**EF-1 & 6 DETAIL**  
NOT TO SCALE

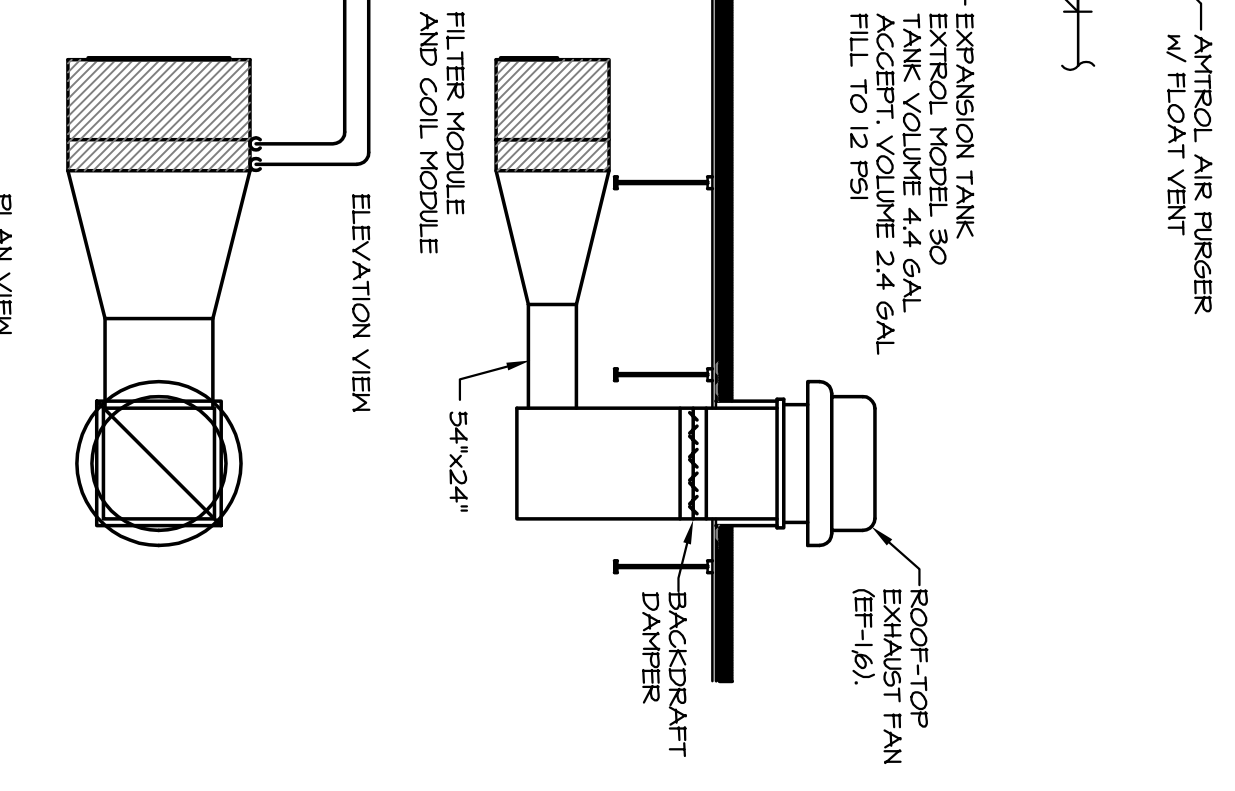
CORRECTION LIST (cont'd.)		
No.	DESCRIPTION	Code Section
	Need info regarding exhaust for rear area.	
	1.5 CFM / PE SAFE TABLE W/ 1604.3 1993 BCAA MECH	
	878-5235	
	TITAN MECH	
	John Vaccaro	
	Door schedule that corresponds to door number on plan not shown on A4.0 or in spec book.	
	End of Dwp. HUMAN	
	Window/Store front load <del>to</del> impact code + TESTING SQUARE CHAIR 24
